Re: Project No. 10_0185 - Northbank Enterprise Hub - Submission

Please accept the following submission from Port Waratah Coal Services in relation to the Northbank Enterprise Hub project application. Port Waratah Coal Services appreciates the extension of time provided by the Department for the preparation of this submission. Port Waratah Coal Services supports the Northbank Enterprise Hub development in principle subject to the following.

Figure 17 - Peak Water Level Afflux (Proposed – Existing) 1% AEP Event.

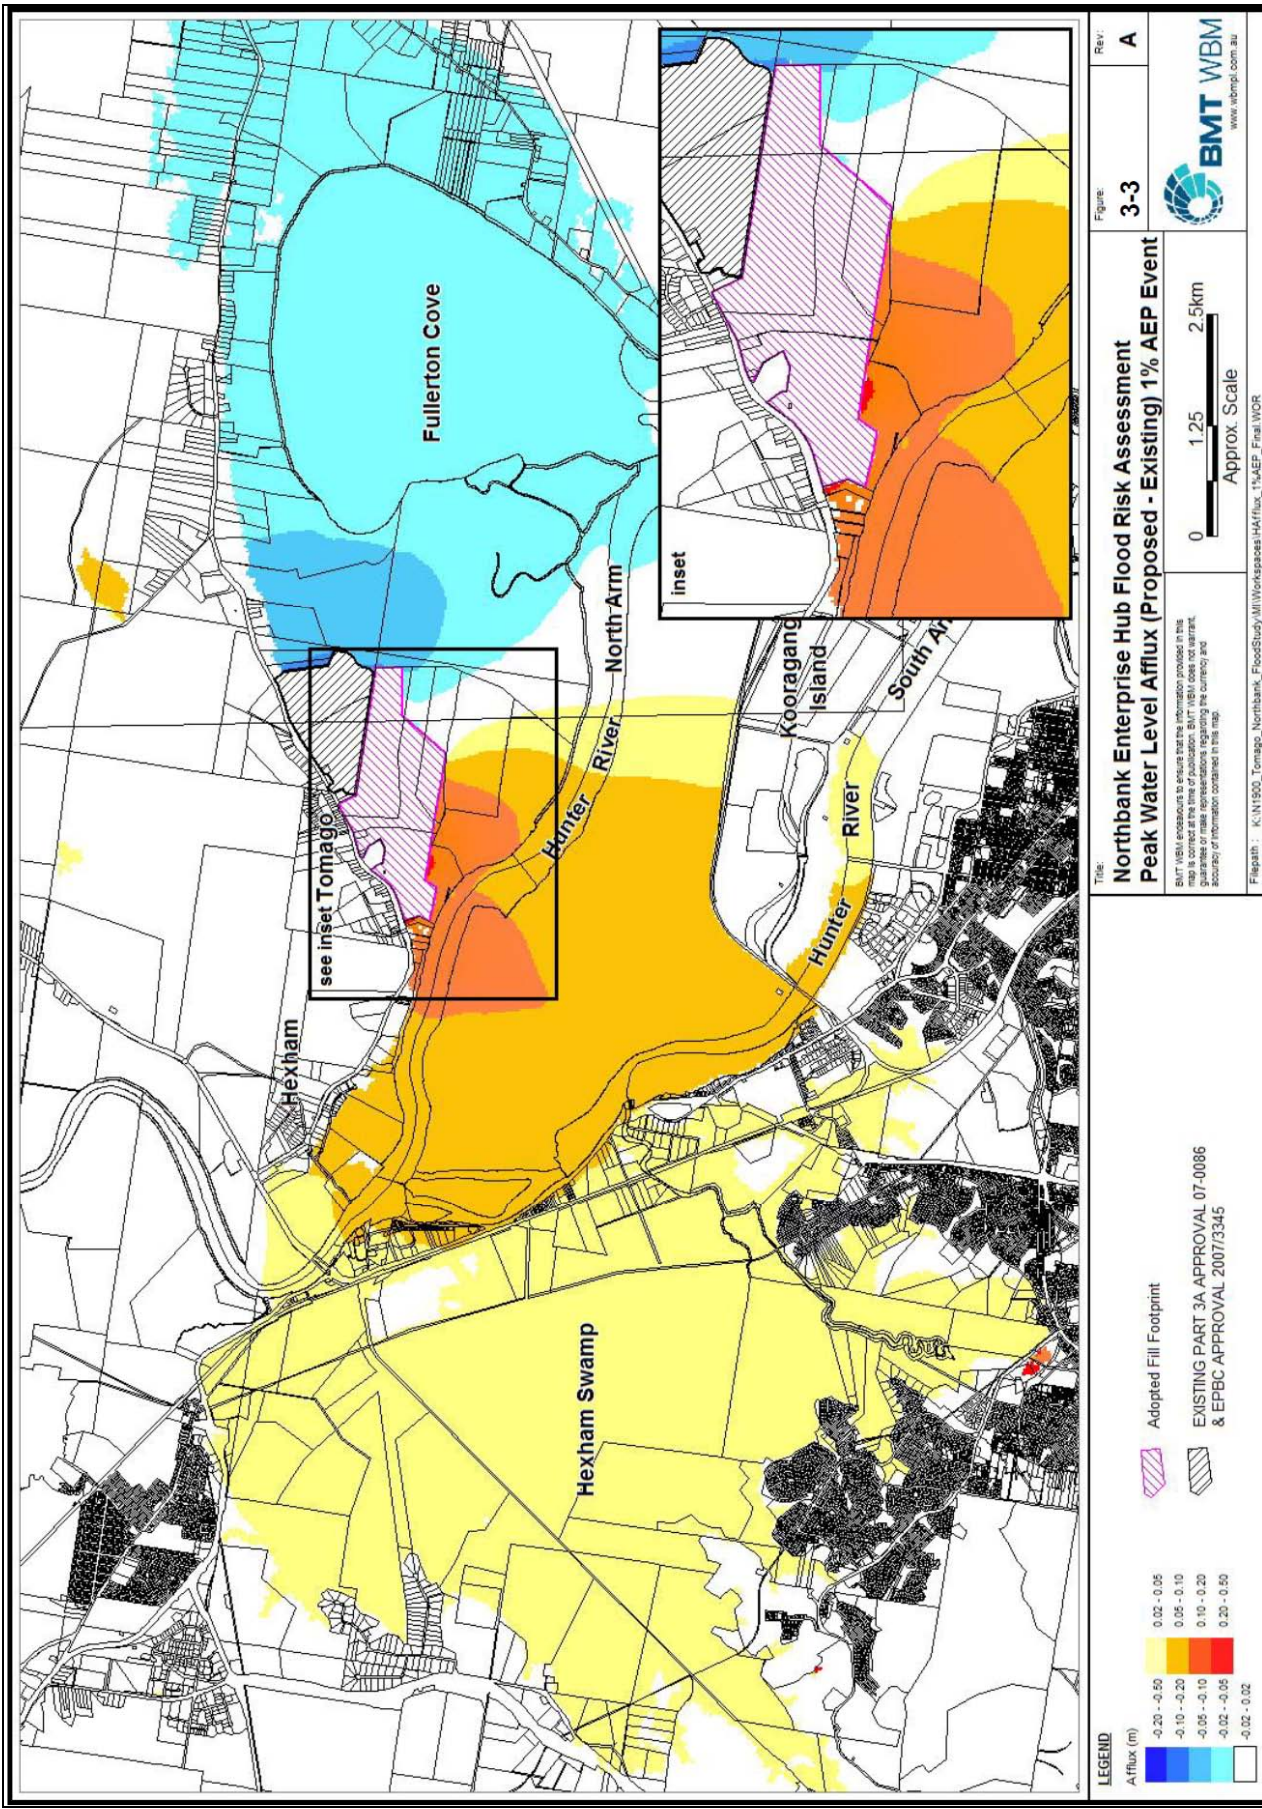
Flood modelling undertaken for the Northbank Enterprise Hub development has identified that the proposed elevation of the development footprint results in an increase in flood levels on the western side of the PWCS land in the 1% AEP event from existing flood depths of approximately 1.0 to 3.0 metres to proposed flood depths between 1.1 to 3.2 metres. The peak water level increase on the western side of the PWCS land of 0.1 to 0.2 metres is consistent for all events from a 5% AEP to a 1% AEP event and may require the implementation of mitigation measures.

The existing peak velocities on the PWCS land range from 0.6 m/s to 0.8 m/s on the western side and 0.4 m/s to 0.6 m/s on the eastern inland side of the lot. Modelling indicates that the proposed development will cause an increase in peak velocities in the PWCS land during a 1% AEP event to 0.6

m/s to 1.1 m/s at the centre of the site (i.e. an increase of between 0.2 m/s to 0.5 m/s). The increase in velocity on the PWCS land reduces for the 5% AEP event to increases of 0.1 m/s to 0.2 m/s above existing conditions. The increase in peak flow velocity will potentially remain non-scouring within the PWCS land, however, this should be confirmed by the Northbank Enterprise Hub assessment to ensure that it does not adversely affect the conservation value of the PWCS land.

Port Waratah Coal Services note that the Northbank Enterprise Hub has specified that local works such as minor bunding and filling can be undertaken to mitigate impacts if required. It should be confirmed by the Northbank Enterprise Hub what mitigation works would be undertaken to ensure that the predicted flooding impacts of the Northbank Enterprise Hub do not adversely affect the conservation value of the PWCS land.
